**From:** Dominic Gothard <[REDACTED]>  
**Sent:** 24 February 2020 22:59  
**To:** Anita Gardner <[REDACTED]>  
**Subject:** Little Deerswood Planning Application - K/32/18/PL (Resent with additional attachment)  
**Importance:** High

Whilst this new application sets the footprint ever so slightly further away from the boundary with our property, the overall profile of the side elevation facing us is almost identical to the previous application (refer to application drawing SK 125). The height is no lower than the refused application and the elevational profile or silhouette is no less great.

1703 SK125
Little Deerswood, Kingston Gorse
East Elevation
Scale 1:100

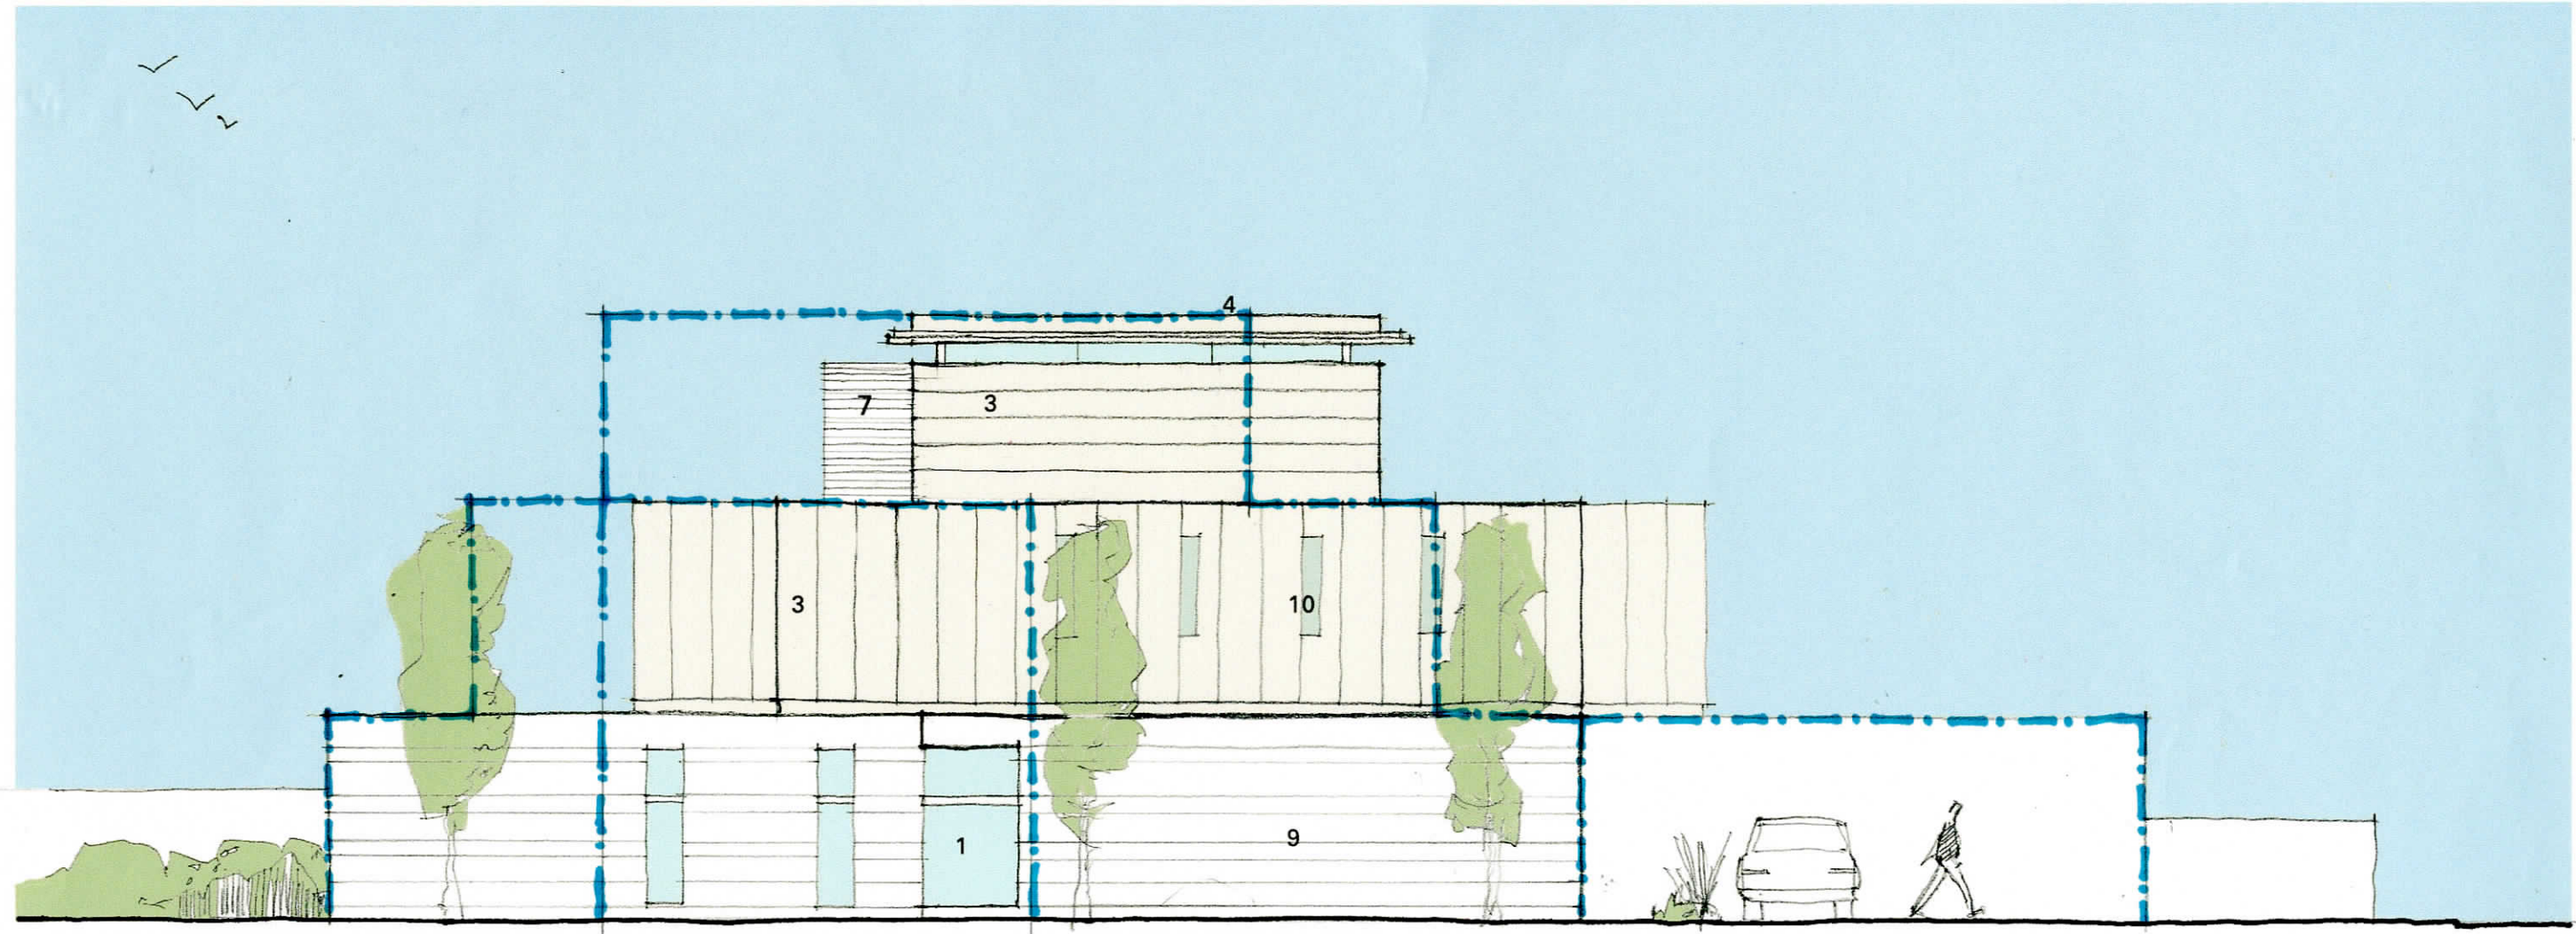
The applicant has made little attempt to mitigate the impact that the house will have on our plot. As with the previous application, the proposed 3 storey form will create an oppressive and acutely overbearing presence on our front garden.

Aside from a small token projection, the east elevation is a sheer 3 storey form that will be visually oppressive and that will completely overshadow the front part of our garden for 6 months of the year from 2pm onwards - see attached shadow diagram.
